OBSERVATION/SUBMISSION TO PLANNING APPLICATION

Case Reference: 324113

Re: Observation to the proposed development of open-cycle gas turbine (OCGT) and generator with ancillary equipment.

Location: Pollnagroagh and Rathmorrissety (Townlands), Athenry, Co. Galway

Purpose		PLANNING			
Title		SITE ACCESS SIGHTLINES			
Original Scale	Design/Drawn	Checked	Authorised		
SHOWN at A1	PS	ND	AJB		
Date	Date	Date	Date		
01.12.25	01.12.25	01.12.25	01.12.25		
Status	Drawing Number	Rev			
A2	PEK3-ATK-ZZ-01-DR-CE-901200	0

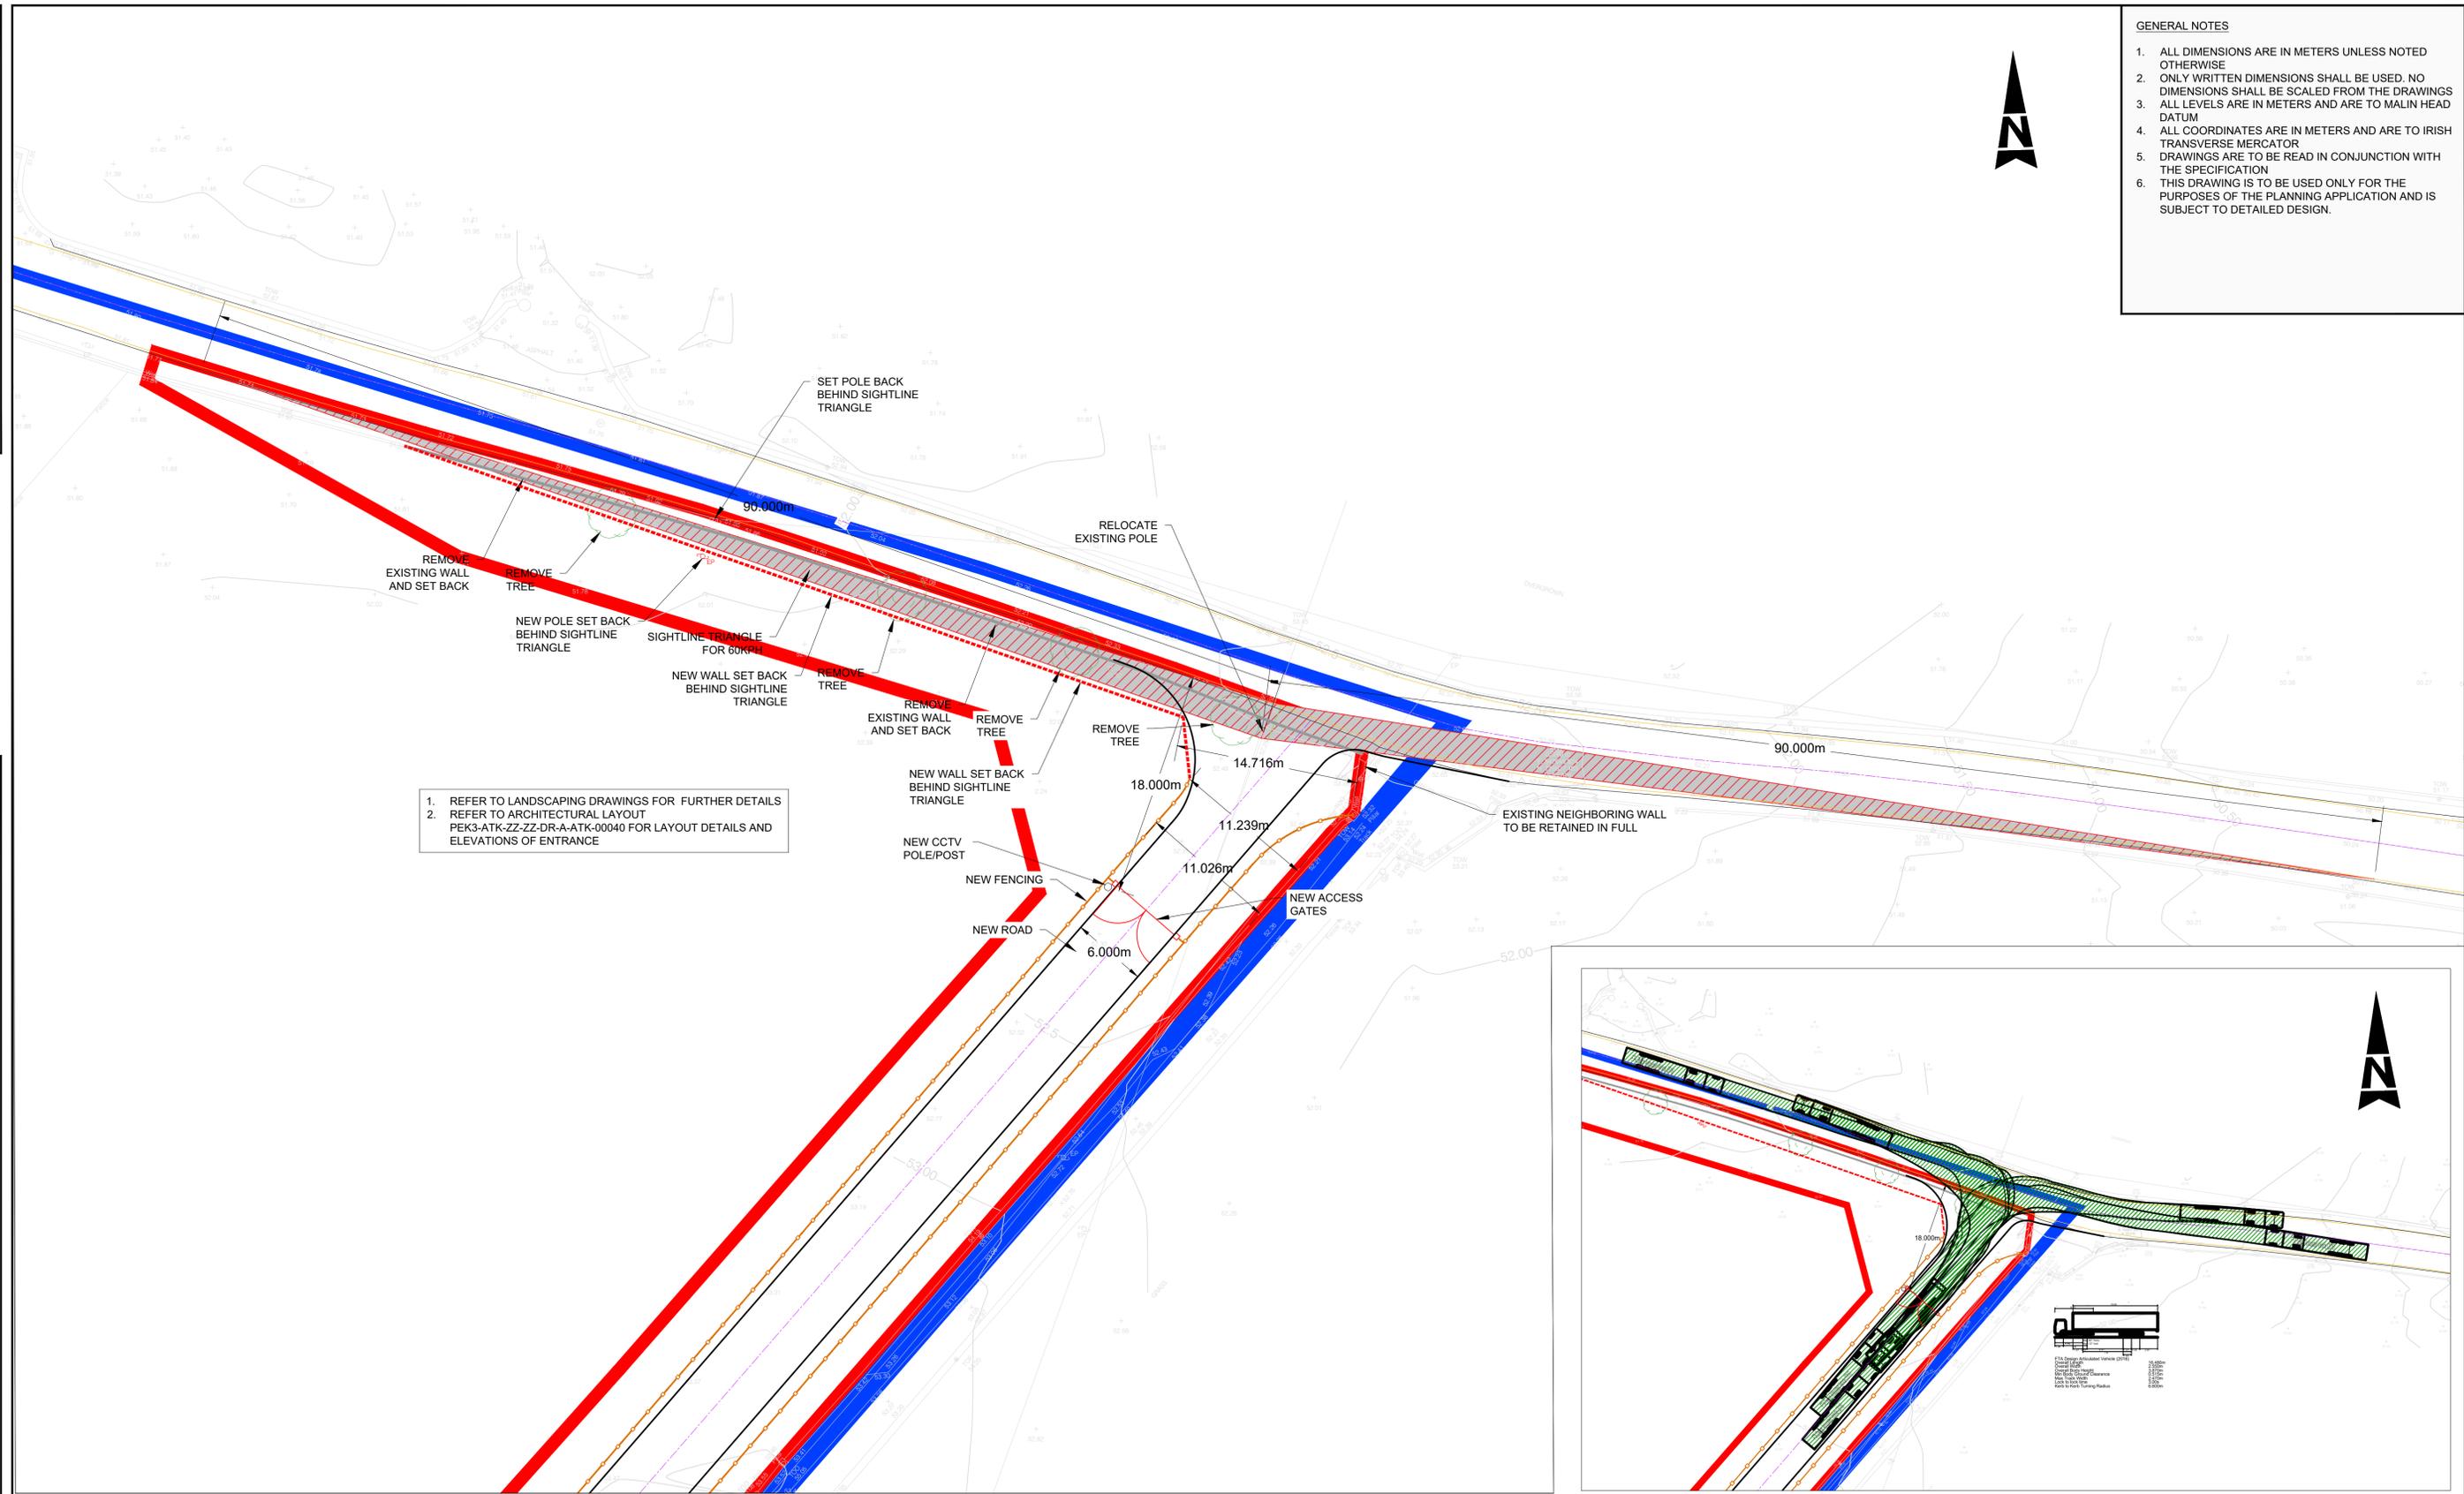
We have concerns in relation to increased heavy traffic and diesel transportation risks. As residents who use this road, we are worried about road safety in relation to the proposed entrance on the L3103. This stretch of road is already extremely narrow, with no hard shoulder, making it difficult for two heavy goods vehicles to pass safely and leaving no margin for error. Visibility is also poor due to blind dips and sharp bends, meaning drivers often cannot see oncoming traffic in time. The proposed development would increase traffic levels, including heavy goods vehicles, construction traffic, and fuel deliveries such as diesel tankers, all of which require space and clear sightlines that this road does not provide. Given that these rural roads are used by residents, farm machinery, and school-related traffic, the addition of significant industrial traffic would increase the risk of accidents and create a more hazardous environment. Overall, there is strong concern that the existing road infrastructure is not suitable for this level of traffic and that the associated safety risks to road users, residents and school children have not been adequately addressed.
